RE: NEW LIFE HOMES- AIRPORT RD NW (K-10/D41)
Grading and Drainage Submitted for Building Permit and SO19 Approval
ENGINEERS STAMP DATED 6/1/2002

Re: New Life Homes Drainage Report
Engineer's Stamp dated 6-1-02 (K10/D41)

Based on information provided in your submittal dated 7-11-02, the above referenced report cannot be approved for Building Permit or SO#19 until the following minor comment is addressed.

GRADING AND DRAINAGE PLAN

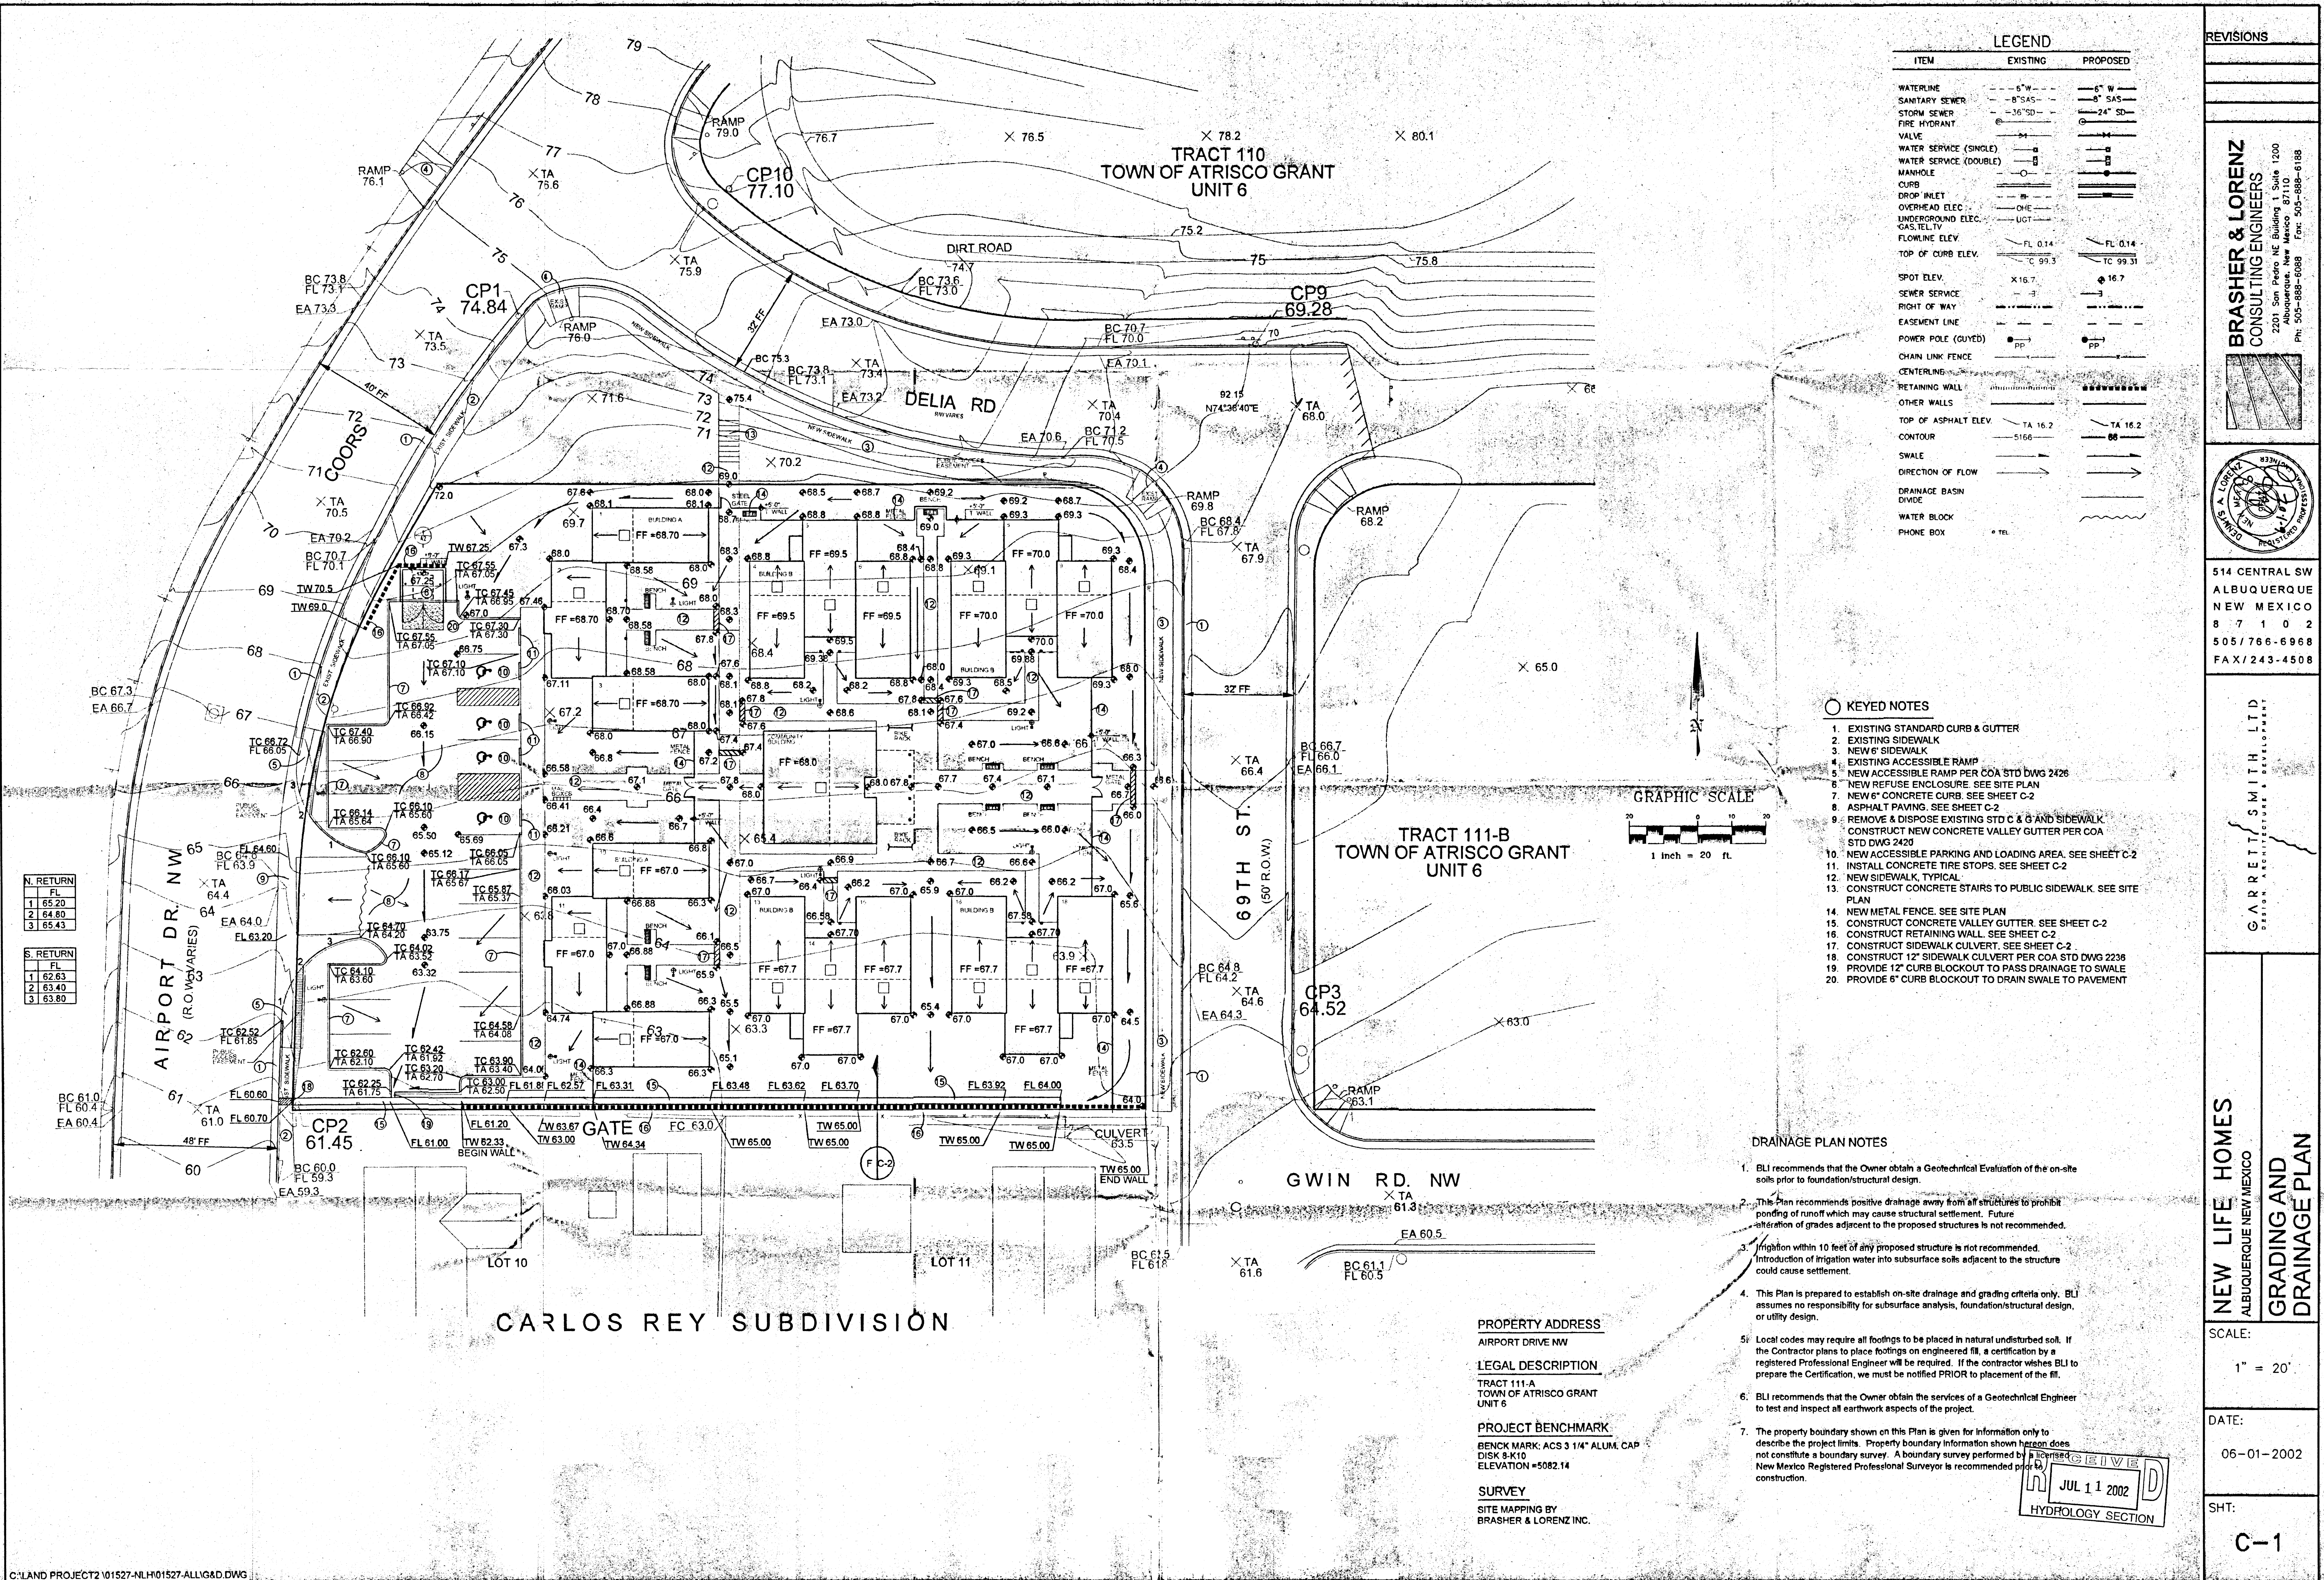
- The construction of the sidewalk culvert on airport road will require an SO#19 Permit. Please provide the applicable notes and signature block on the grading plan and reference the City Standard Drawing. I will also need an extra copy of the grading plan for the inspector.
